Peppertree Quarry Modification 5

ENVIRONMENTAL ASSESSMENT PRELIMINARY RESPONSE TO SUBMISSIONS

Prepared for Boral Quarries | February 2019

Figure 6 | Proposed haulage scenarios

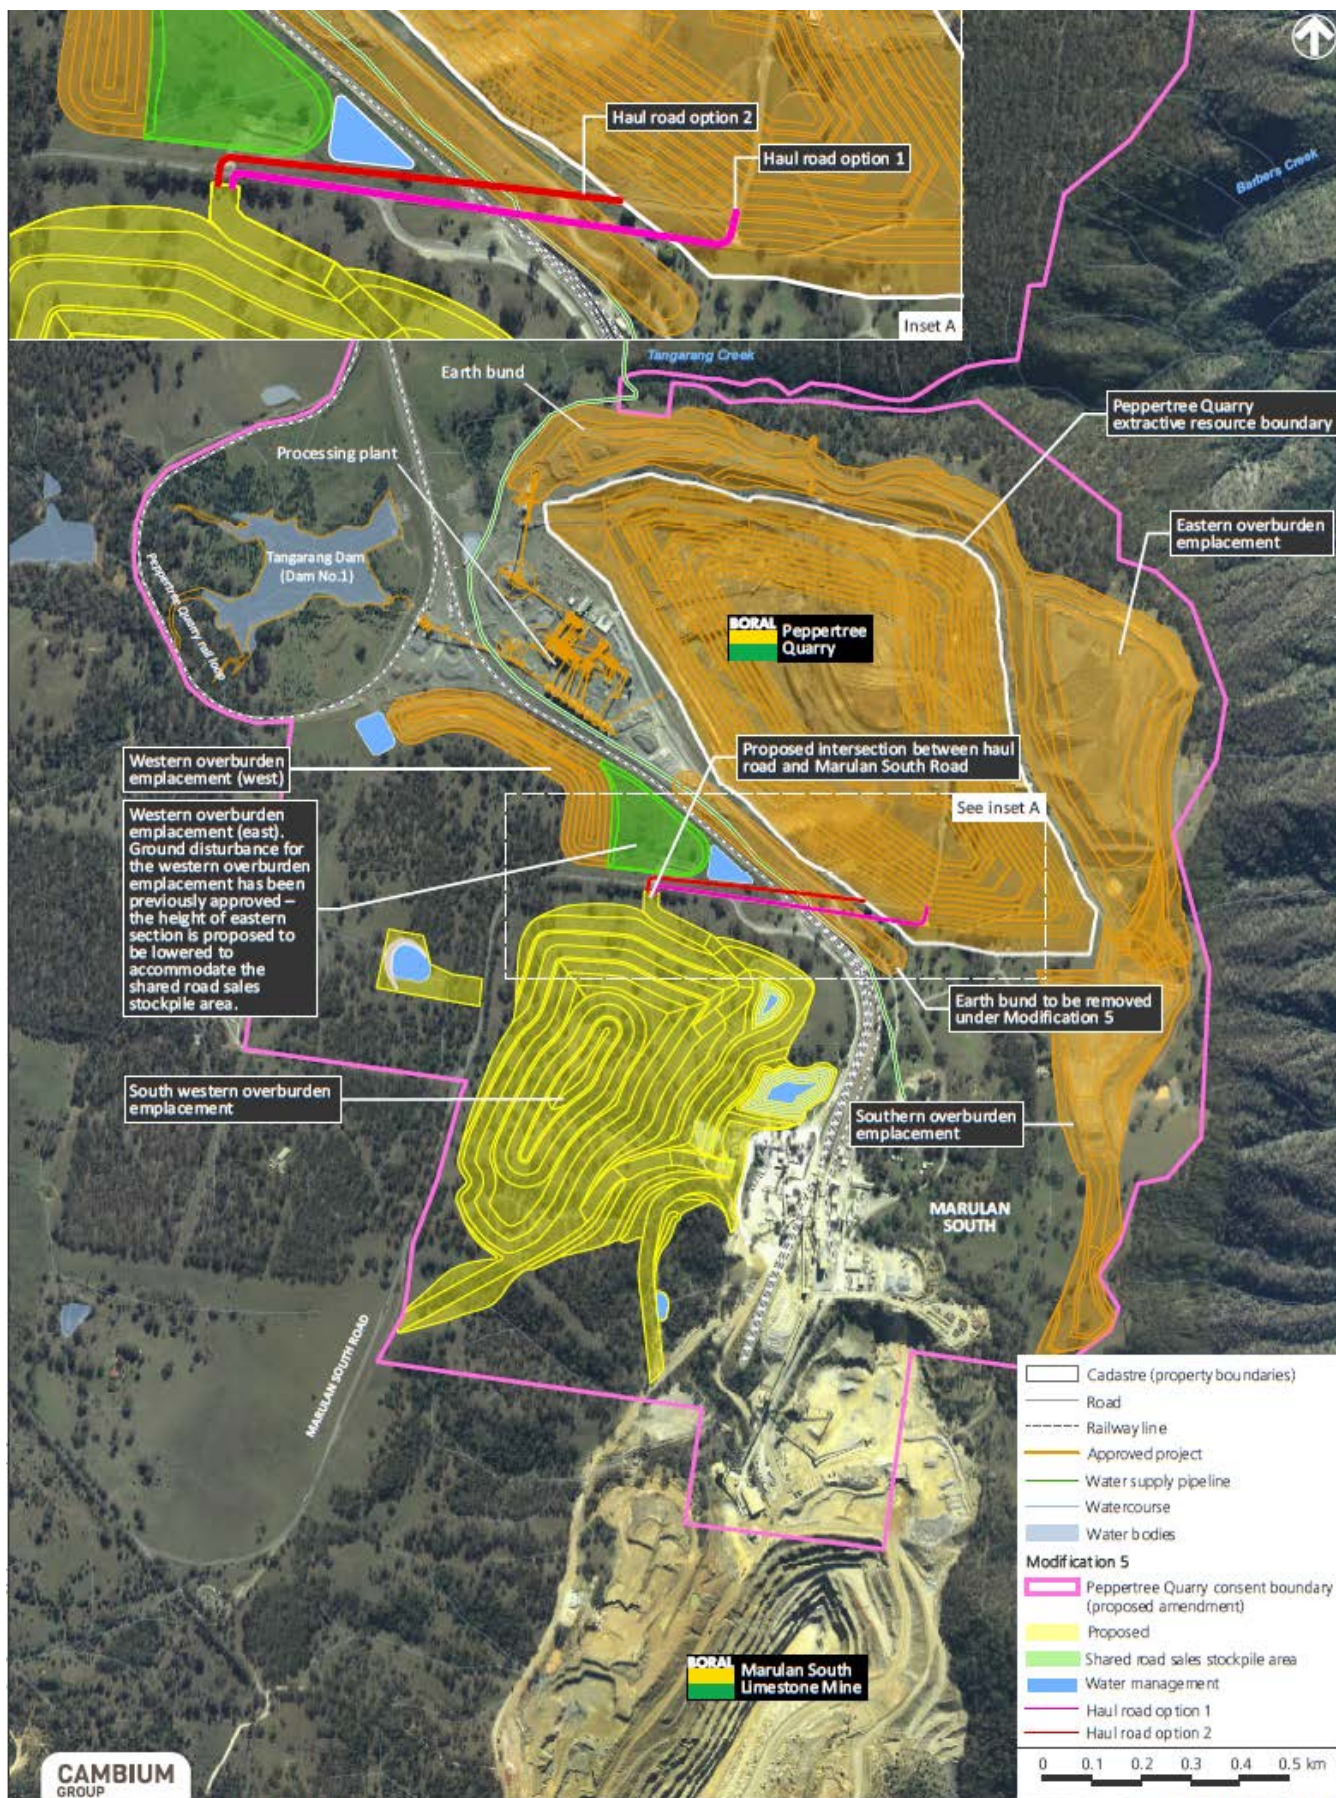
Provide a map which clearly delineates the positioning of the proposed intersection scenarios.

A plan has been prepared by Cambium showing the location of the alternate intersection location (Appendix E).

Figure 1

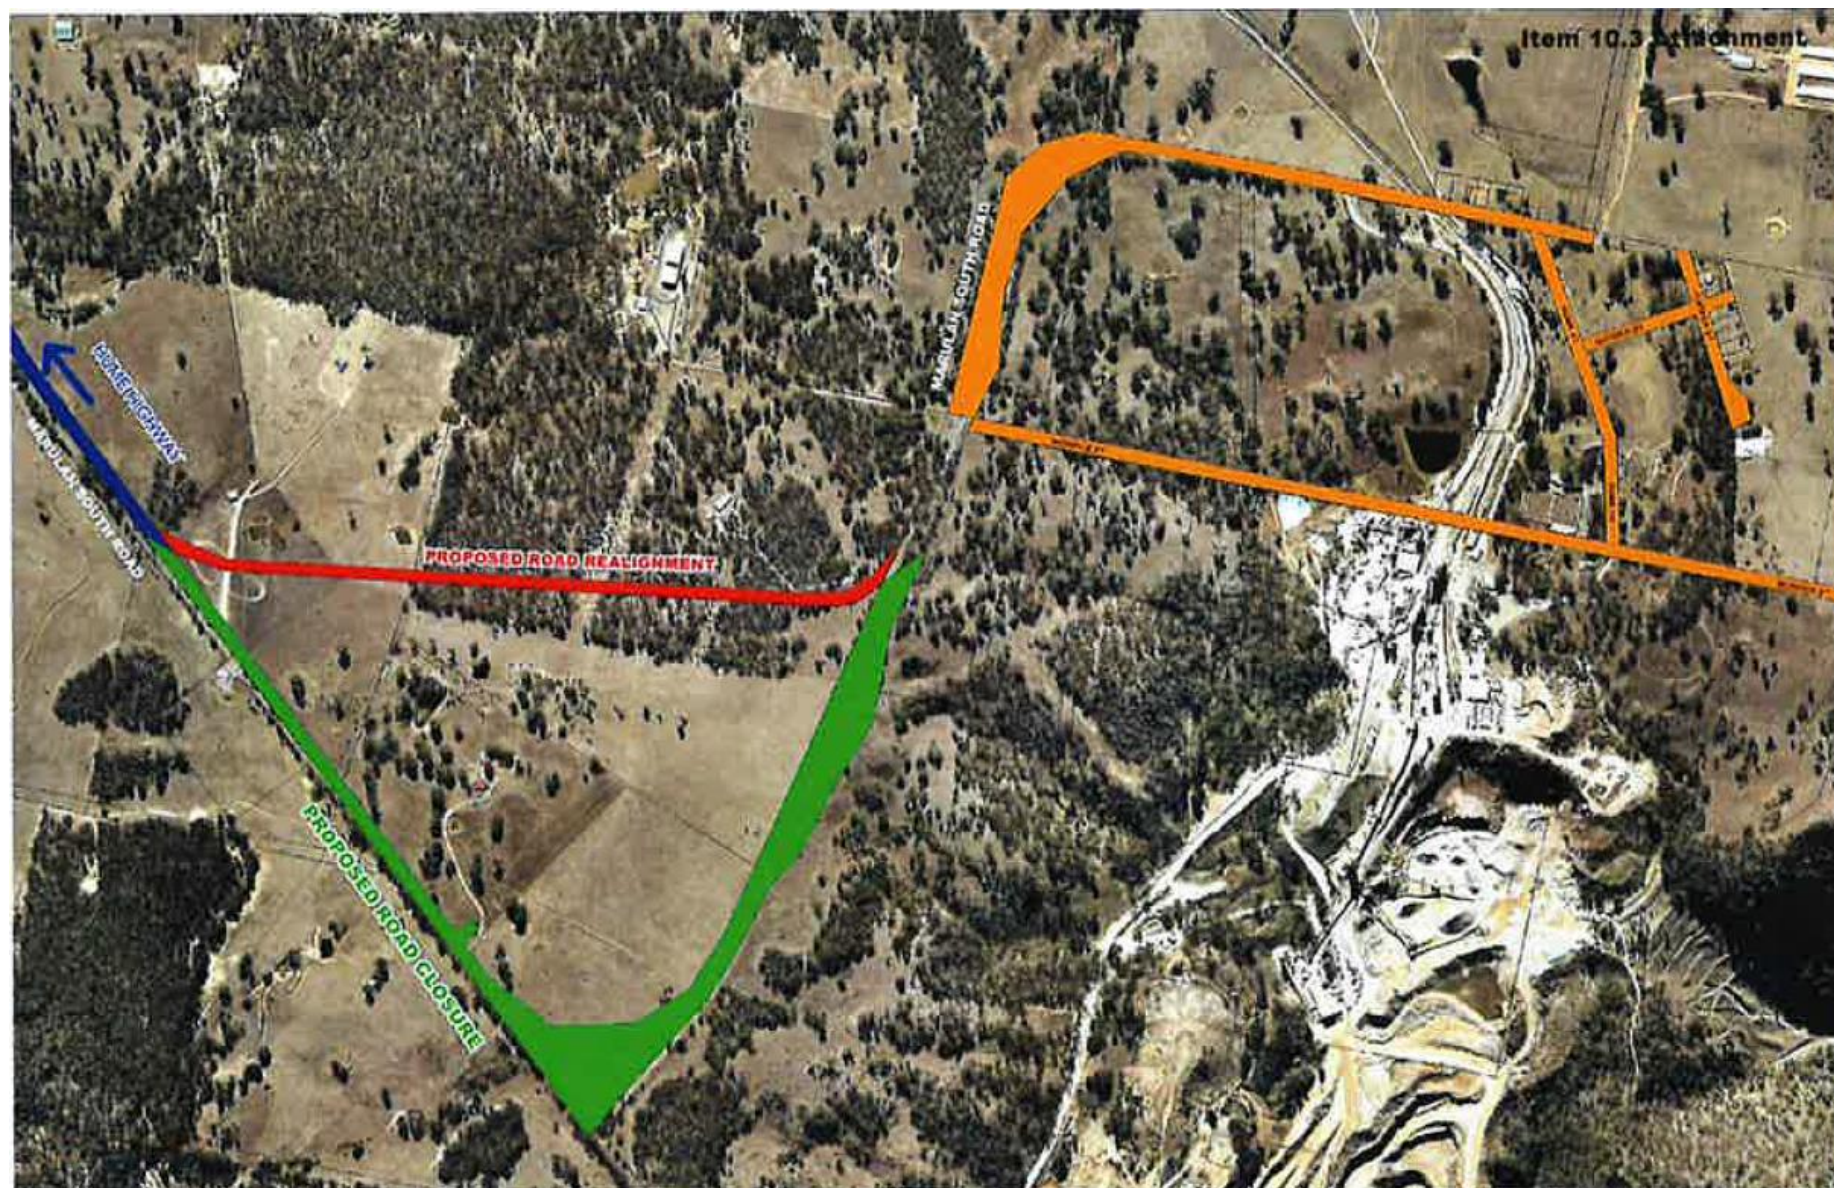
Council is currently negotiating with Boral in relation to the closure and purchase of Council roads within the site (refer Attached, Figure 1). It is recommended that prior to works commencing, all road closure requirements and works are to be finalised.

If the road closure permits are not finalised before this road is operational the haul road will conflict with a public road (Refer Attached, Figure 2).

Council's comments are noted. As set out in section 2.3.2 below, the road closure process is ongoing.

Boral is committed to concluding the Marulan South Road closure process prior to the start of haulage along the proposed haulage road.
